Tel: 01895 250230
Case Officer: Zara Raza
Email: zraza@hillington.gov.uk
Date: 1st June 2022
Our Ref: 77167/PRC/2022/68

RE: Proposed first floor/roof extension to create habitable rooms, rear/front dormer
SITE: 48 Myrtle Avenue Ruislip

PROPOSED FRONT ELEVATION

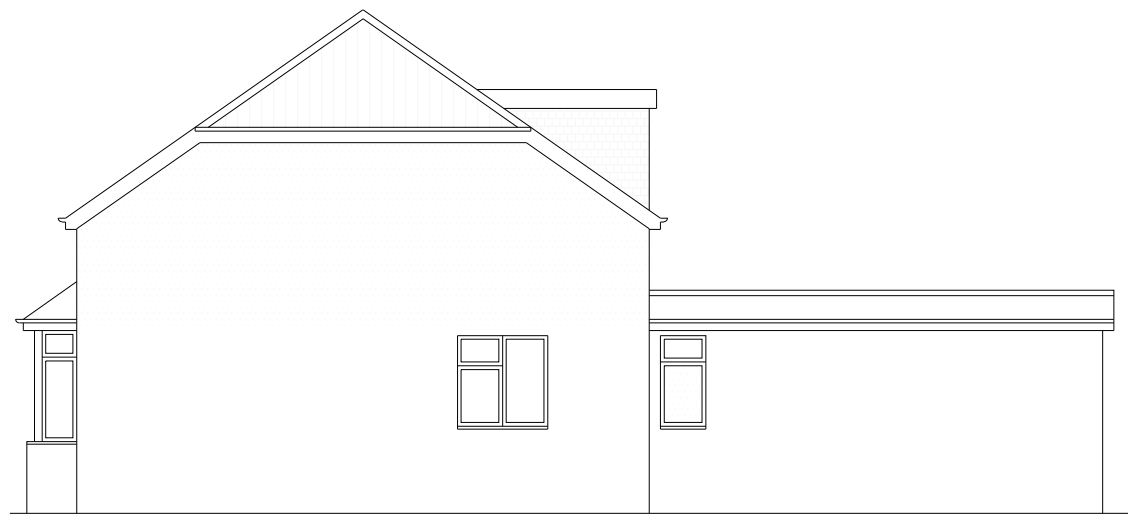
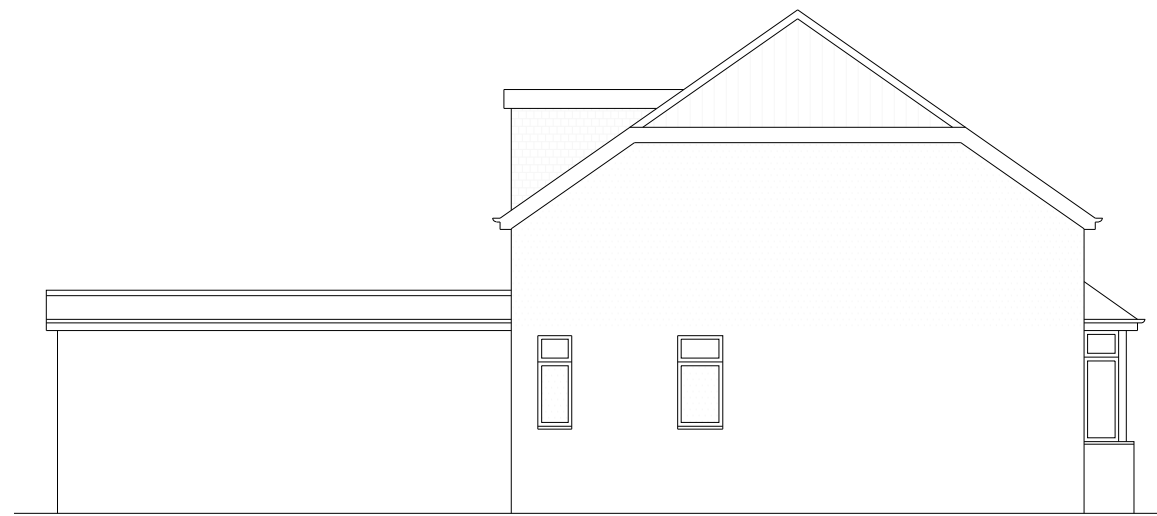
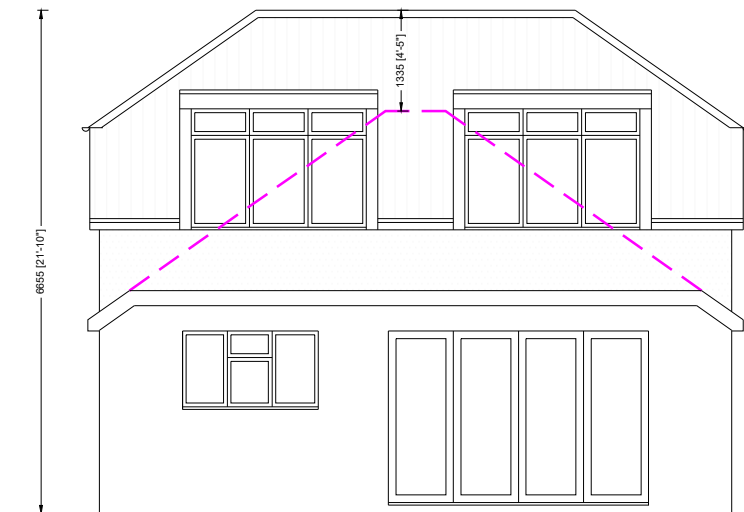
The front dormer would not be considered acceptable given Policy DMHD 1 guidance on roof extensions. The rear dormers are considered to be acceptable in principle, given they do not exceed more than two thirds the average width of the original roof. Whilst there are existing dormers to the front of dwellings in the immediate site context, there does not appear to be any planning consent relating to them and as such they are not considered to justify the proposed front dormer. In any event, any future application would be considered on its own merits and the current proposal is considered unacceptable.

Furthermore, the gable ends to the proposed new roof are not considered to accord with the local context and the change from the existing pitched roof to a mansard style roof with gable ends would not be supported by the Council.

Overall, the proposed first floor extension may be acceptable in principle but it would need to be carefully re-designed so it remains appropriate to the local context. Revisions would need to be made in terms of the first floor mansard style roof design involving a pitched roof to respect the local context and reduce the mass, scale and bulk. The front dormer is not considered acceptable and would be detrimental to the character and appearance of the host dwelling and the street scene despite the varying typology of the design of dwellings on the street. The proposed development would be contrary to the requirements of Policies DMHB 11 and DMHD 1 of the Hillingdon Local Plan: Part Two - Development Management Policies (2020) and could not be supported by the Council.
